**Consultation Response from KC,
Lead Local Flood Authority**

2025/90320 Jewson Property And Services Division, St Andrew's Road, Huddersfield, HD1 6PX

Erection of extension to existing warehouse; demolition of warehouse entrance canopy and southern section of existing warehouse; demolition of existing timber storage area and erection of covered external racking area and associated works

Date Responded: 31/03/2025.

Proposed Layout Plan Showing Catchment Areas (1:1000)

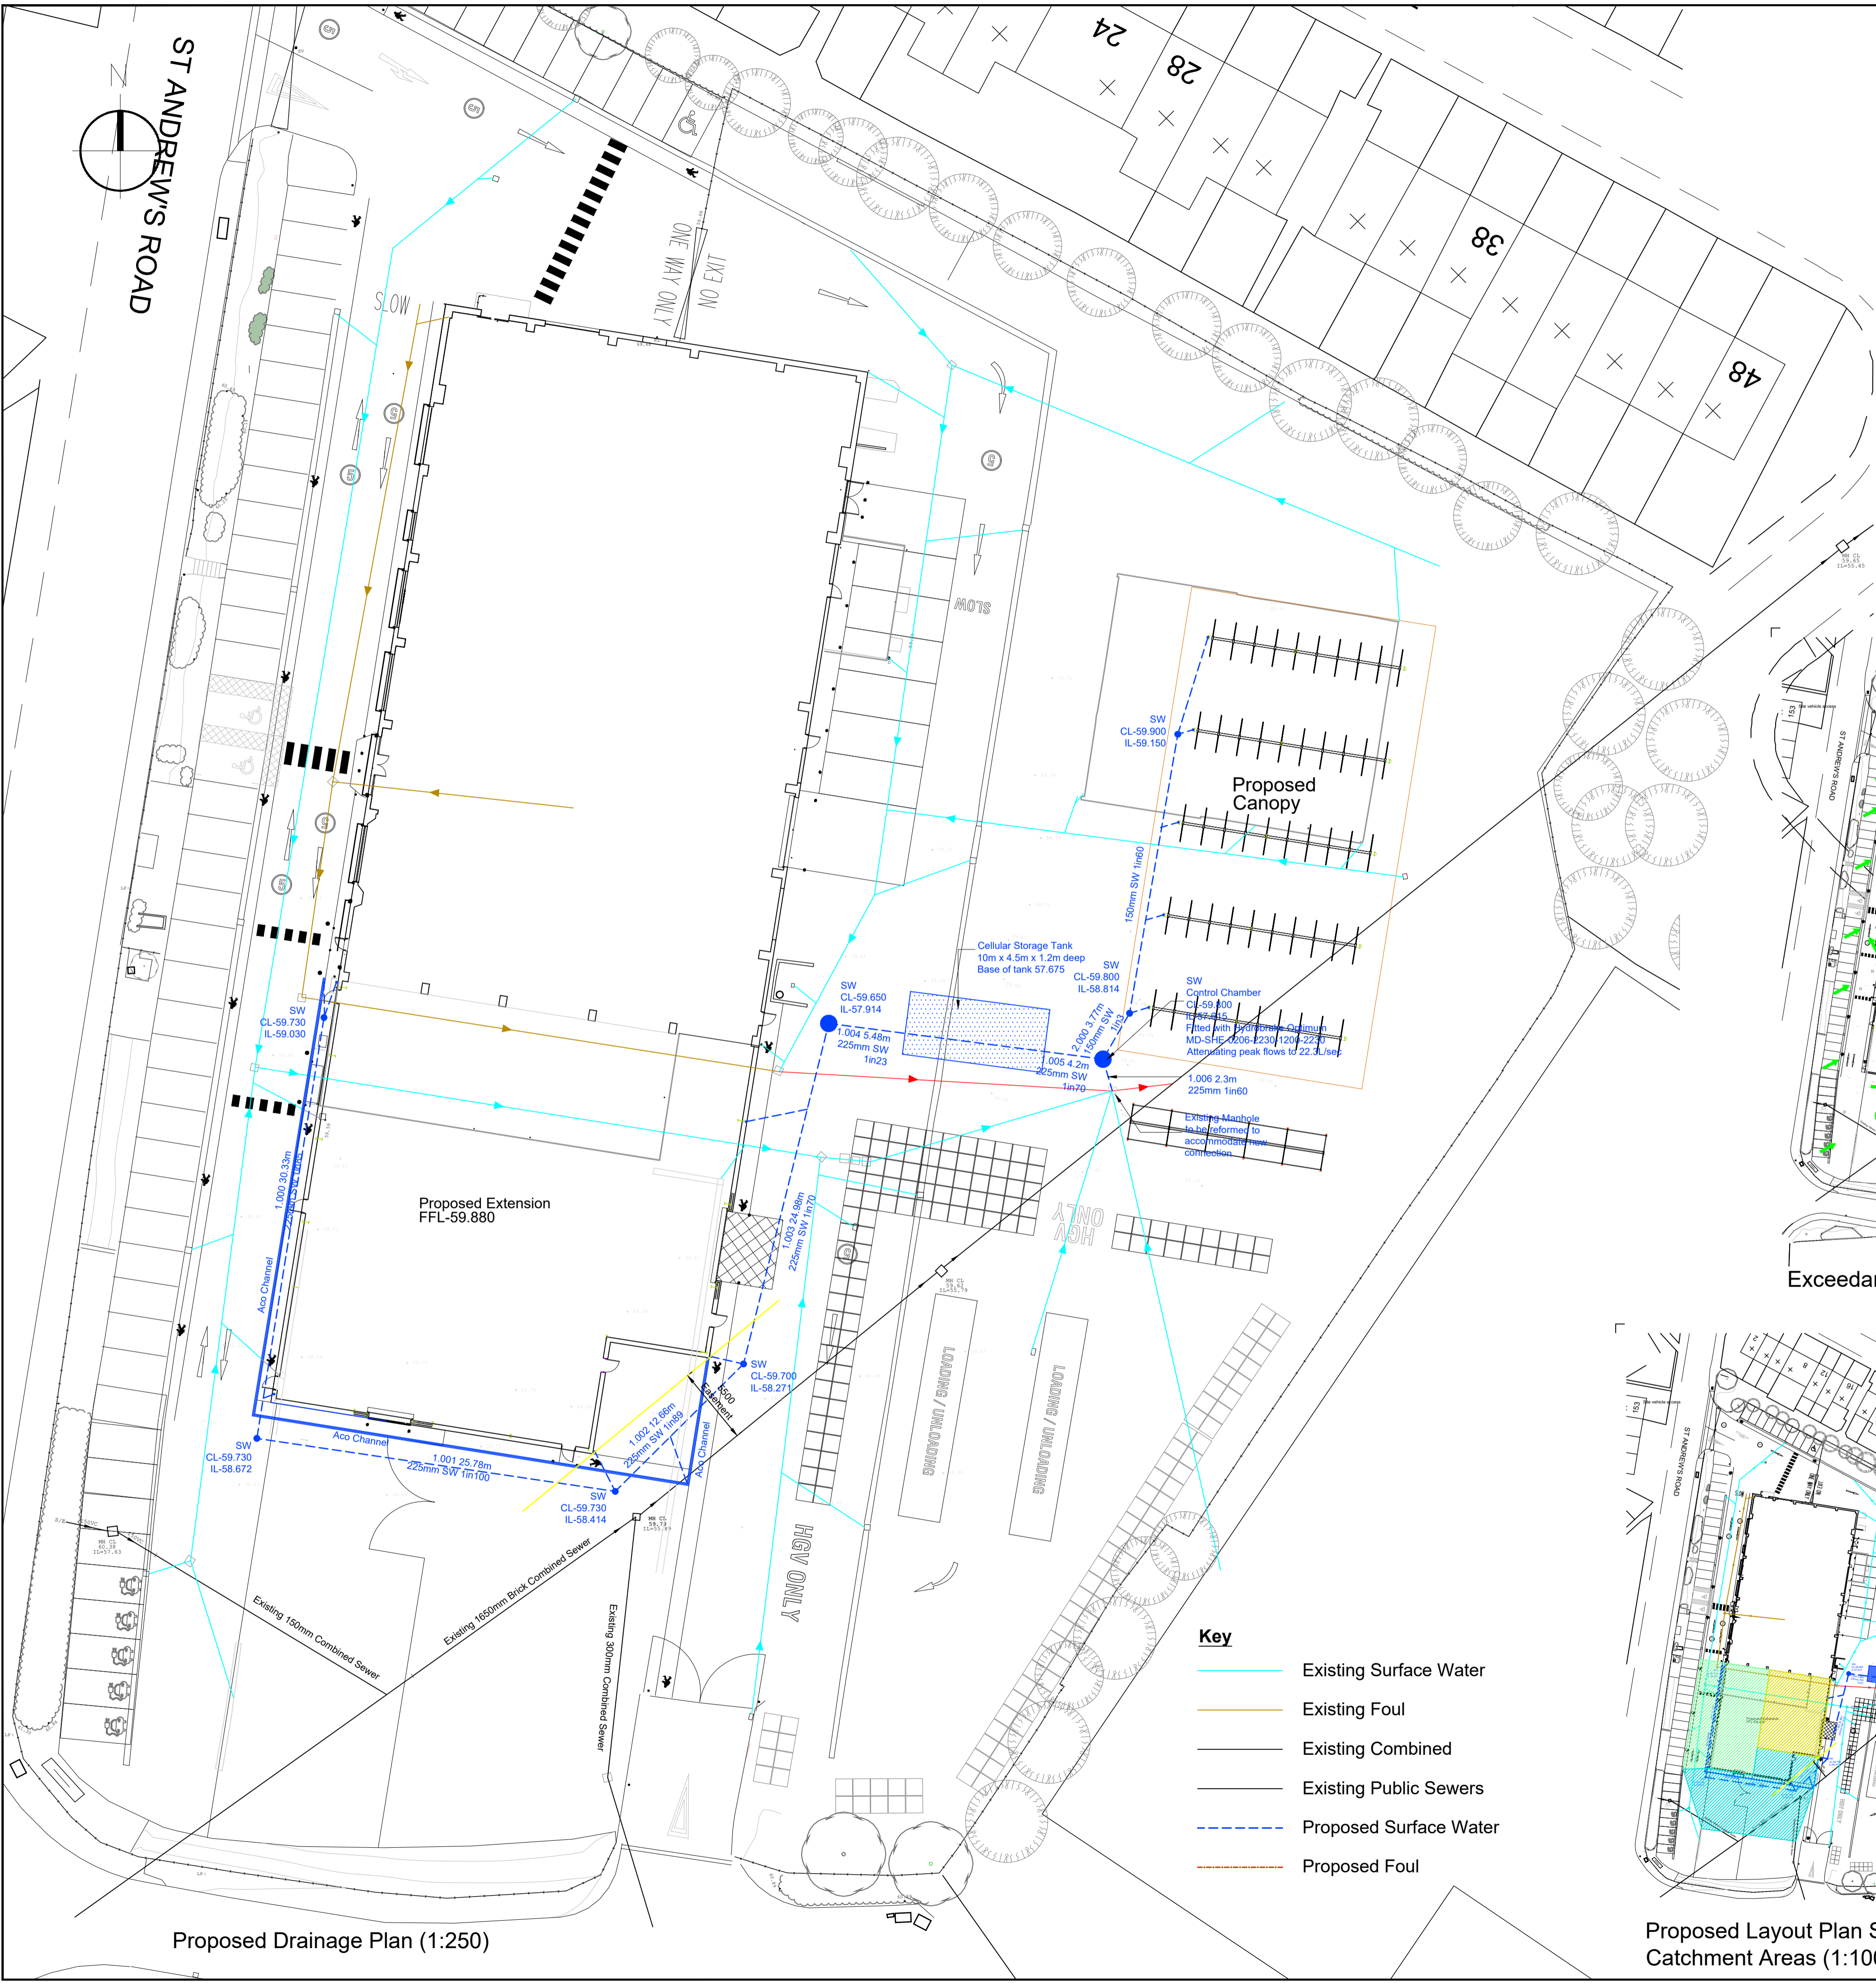
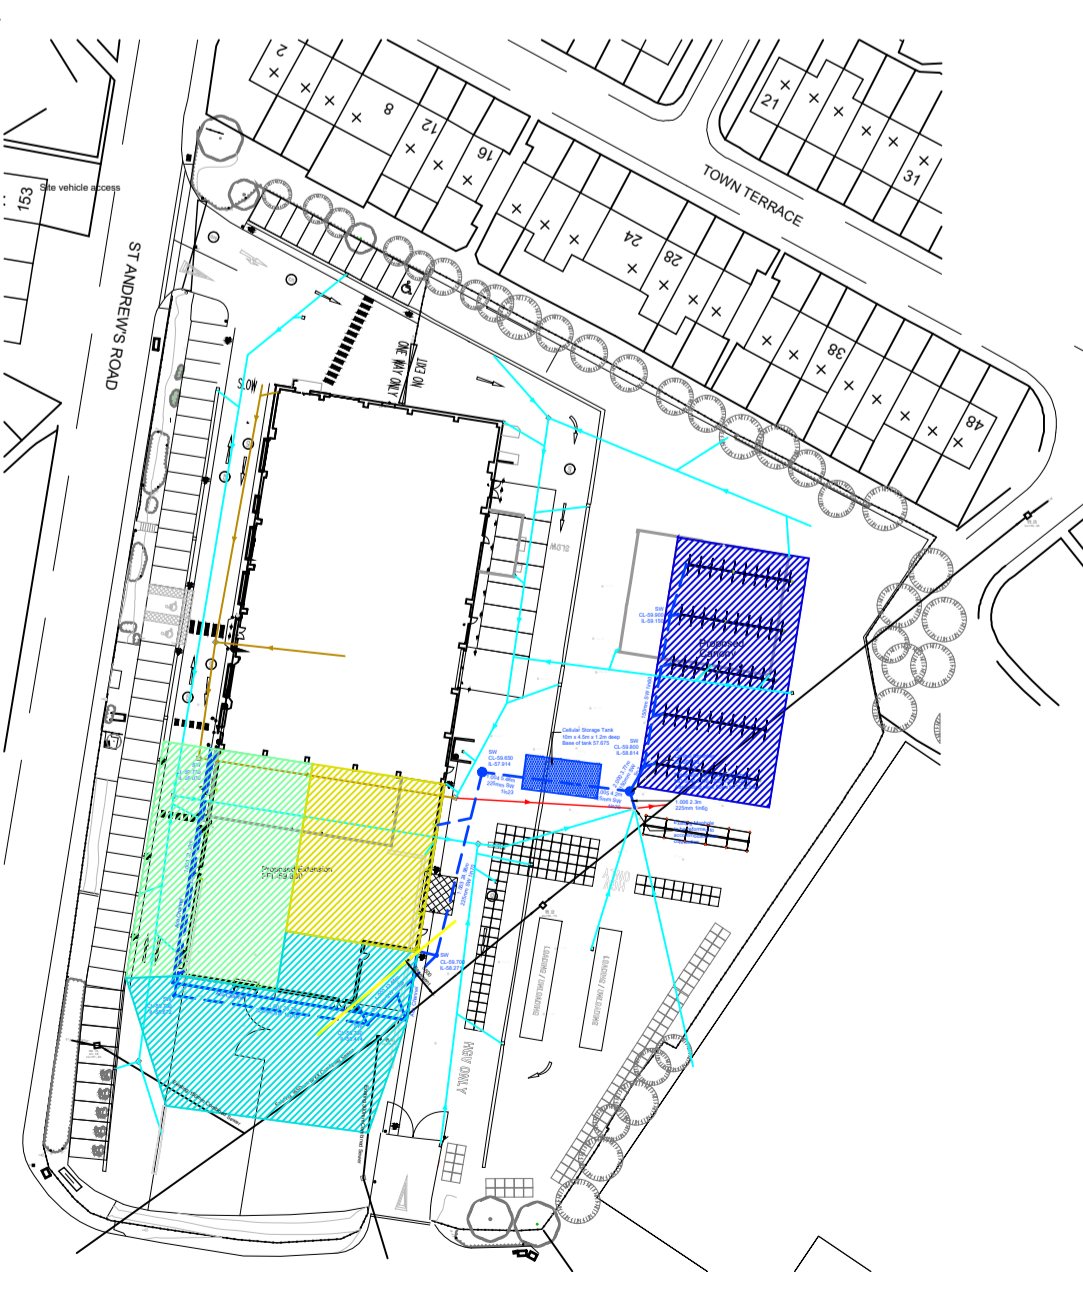
In line with Yorkshire Water's comments, a suitably sized oil separator serving the HGV Loading Area should be installed prior to discharge to the sewer.

It is noted that the car parking area will be below a proposed canopy, therefore this area will not need to drain to the separator.

The LLFA confirms acceptance of the submitted FRA, proposed allowable surface water discharge rate of **22.3l/s**, proposed surface water outfall to the Yorkshire Water combined sewer (subject to YW approvals), the exceedance flow routing and the proposed surface water attenuation (including the associated hydraulic calculations).

Development shall not commence until a scheme demonstrating surface water from vehicle parking and hard standing areas passing through an oil/petrol interceptor of adequate capacity prior to discharge. Roof drainage should not be passed through any interceptor.
